Appeal Decision

Appeal Ref: APP/T2350/W/21/3275319

The Rann, Saccary Lane, Mellor, Blackburn BB1 9DL

- The appeal is made under section 78 of the Town and Country Planning Act 1990 against a refusal to grant planning permission.
 - The appeal is made by Mr Finlay Hodge against the decision of Ribble Valley Borough Council.
 - The application Ref 3/2021/0084, dated 25 January 2021, was refused by notice dated 28 April 2021.
 - The development proposed is the Demolition of existing garage. Extension and alterations to change the use of domestic store to a dwelling.
-

3 PROPOSED SECTION
1 : 50

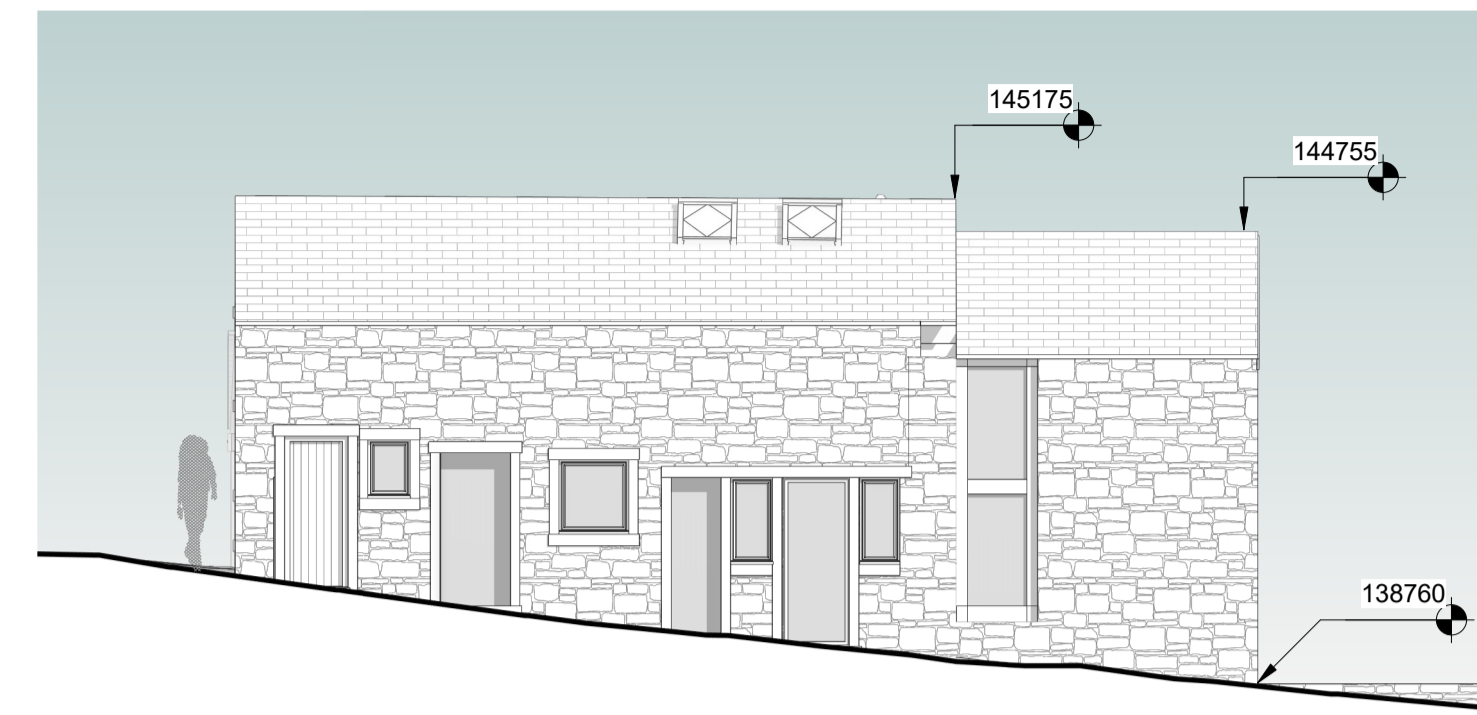
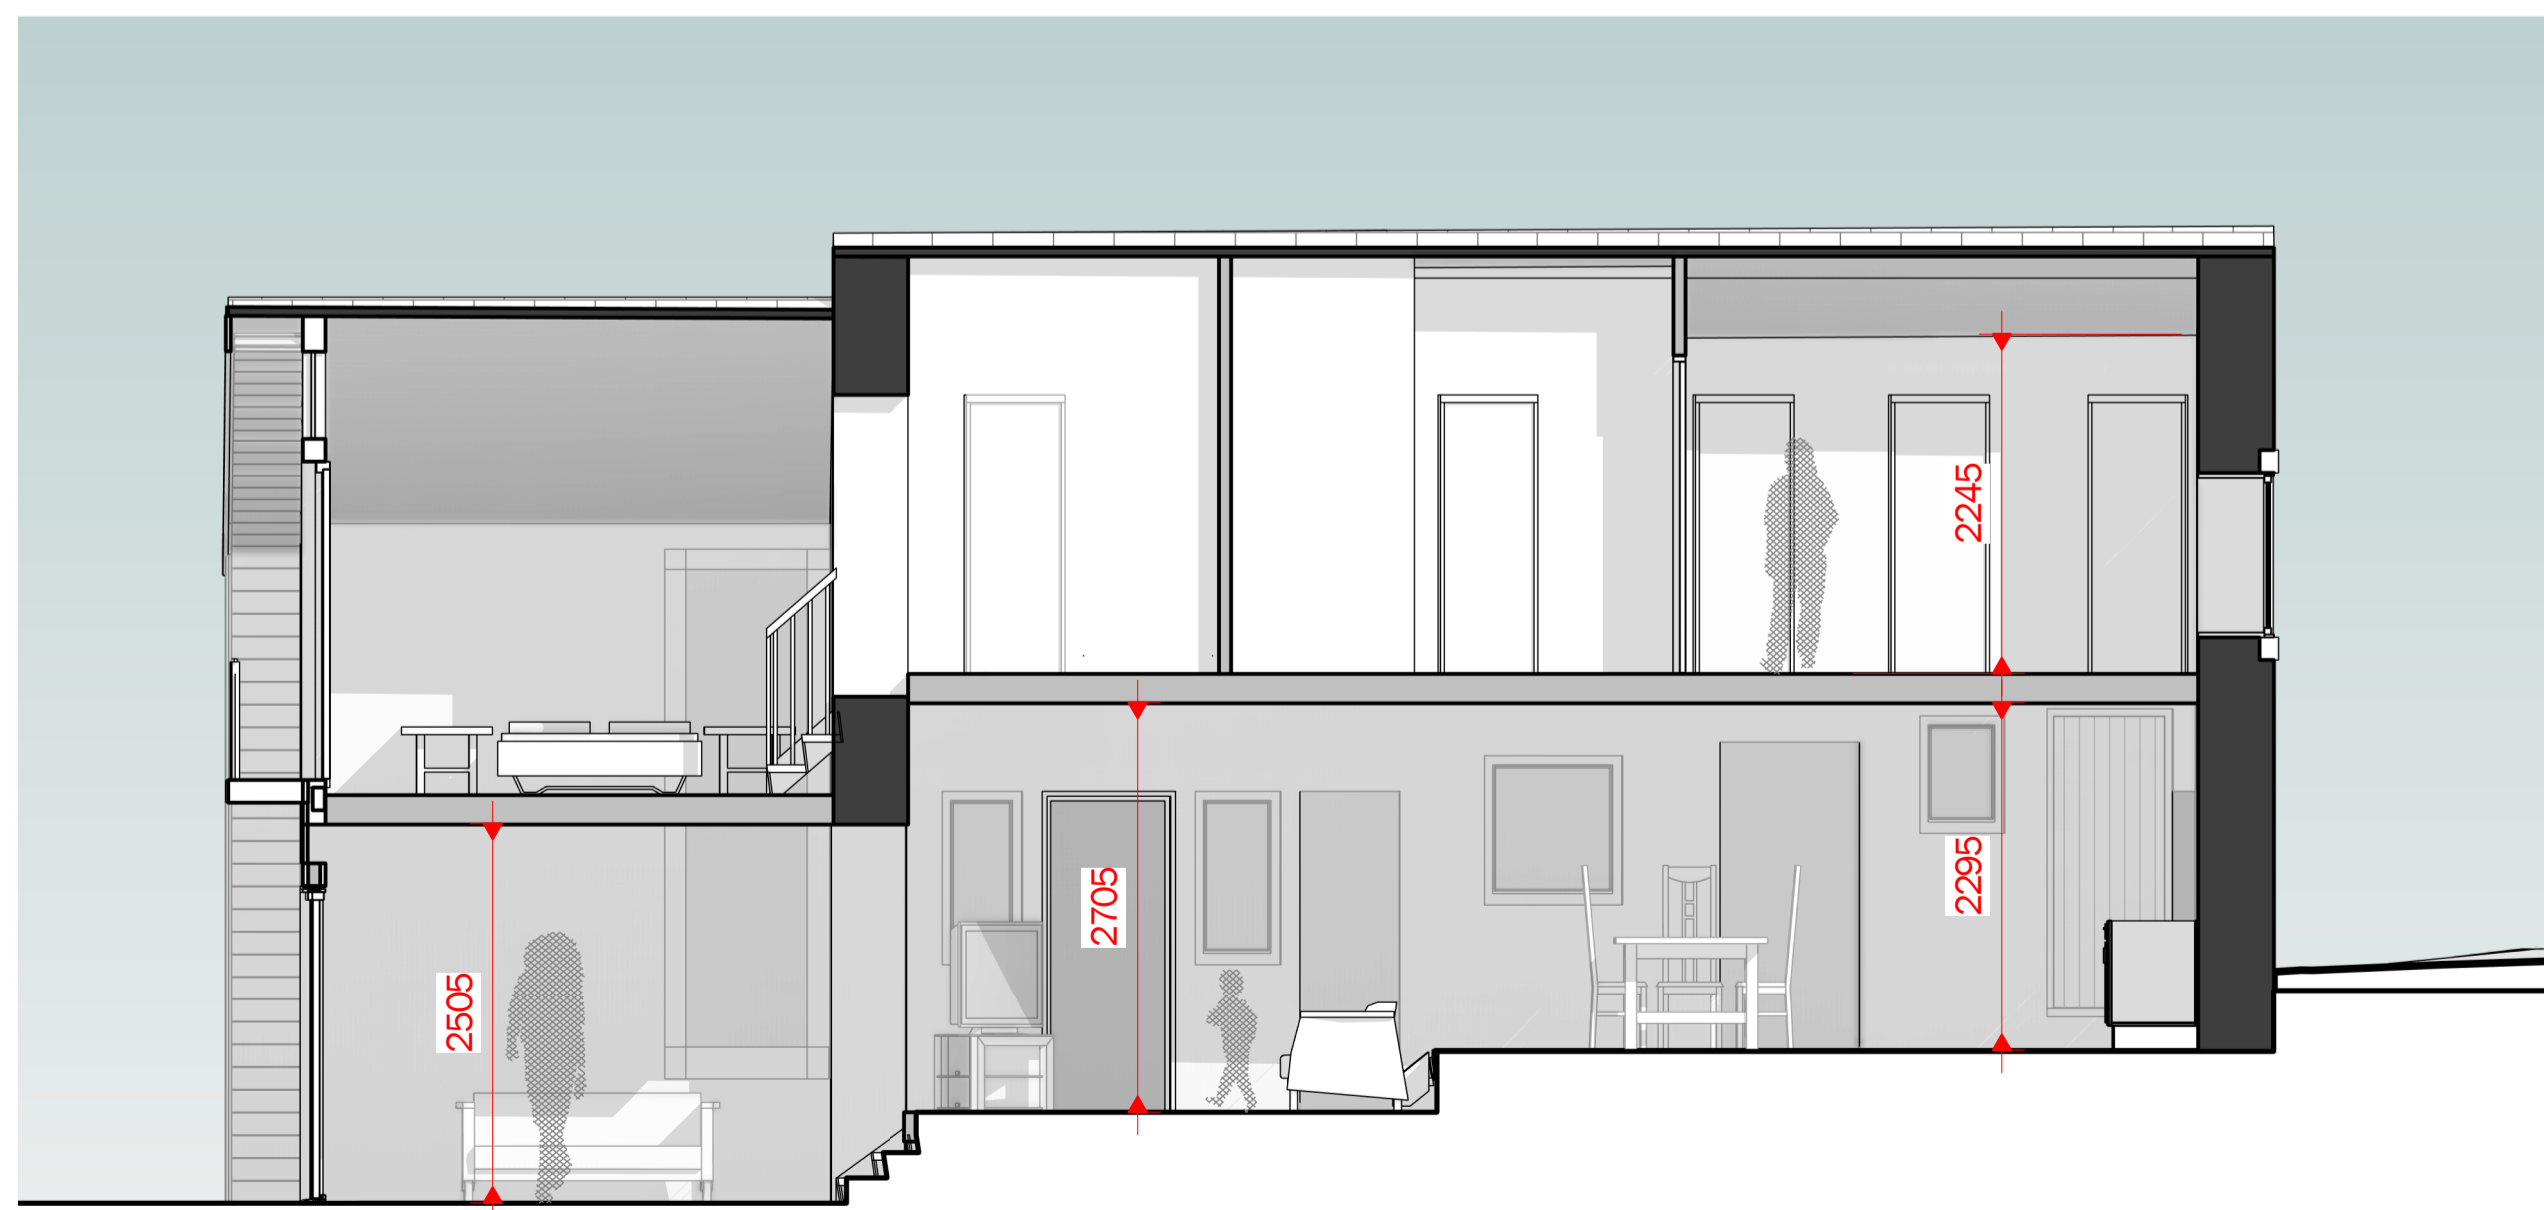
5. Despite its set-down ridgeline, the proposed two storey rear extension would nevertheless have a substantial overall height and footprint. It would therefore introduce considerable massing and appear overly bulky, thus significantly altering the form and appearance of the original building.

5 PROPOSED NORTH ELEVATION
1 : 100

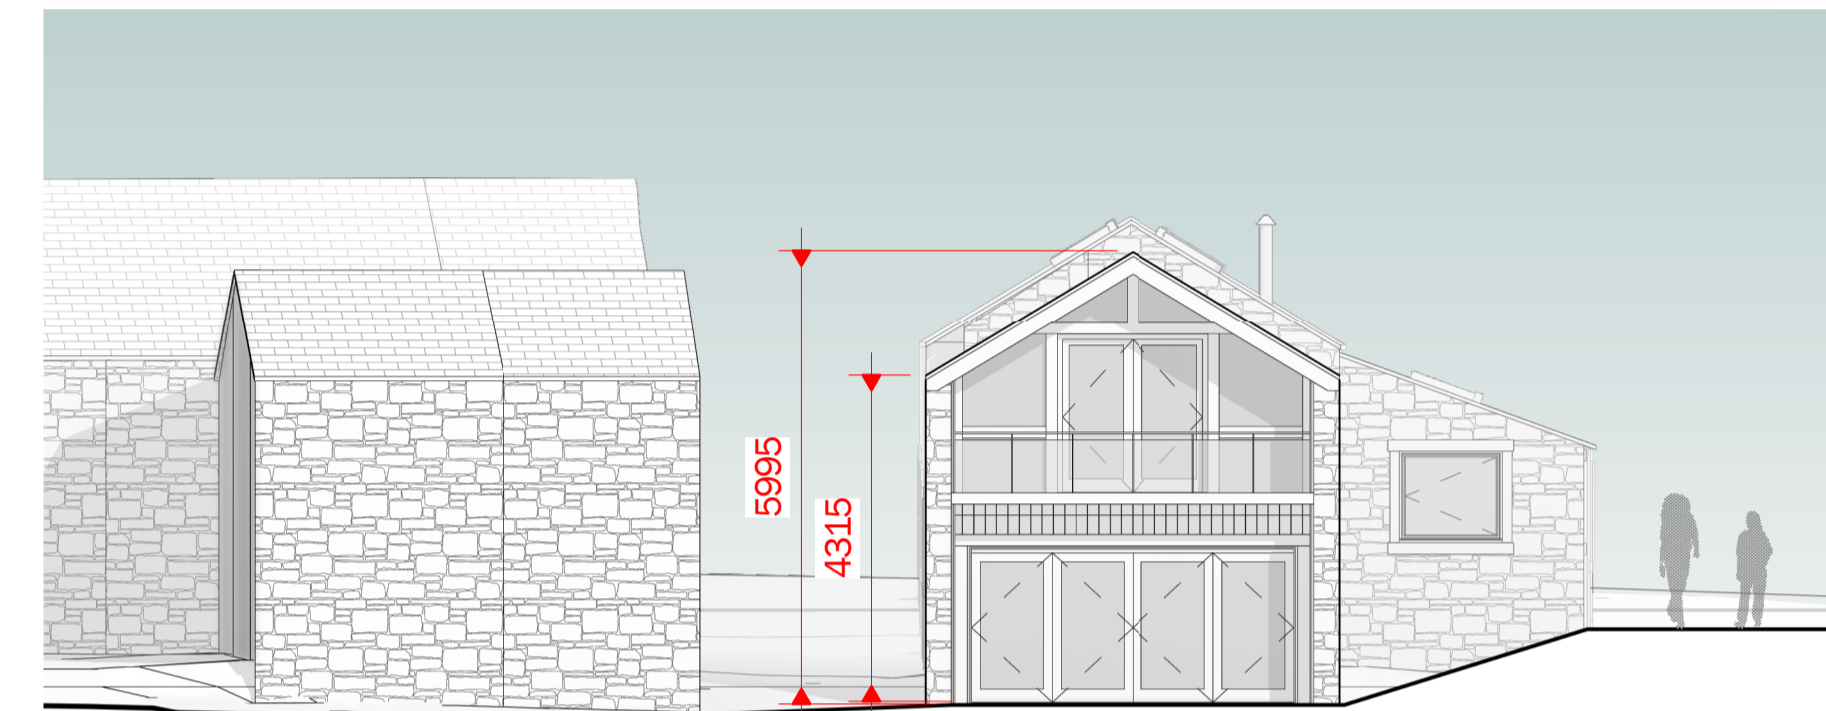
6. The extensive use of glazing on the extension's north elevation would also appear at odds with the building's high stone to void ratio which contributes significantly to its modest appearance. The scale of the extension combined with the substantial introduction of glazing would considerably detract from and be unsympathetic to the simple agricultural characteristics of the built form and it would be visually incongruous within this rural locality.
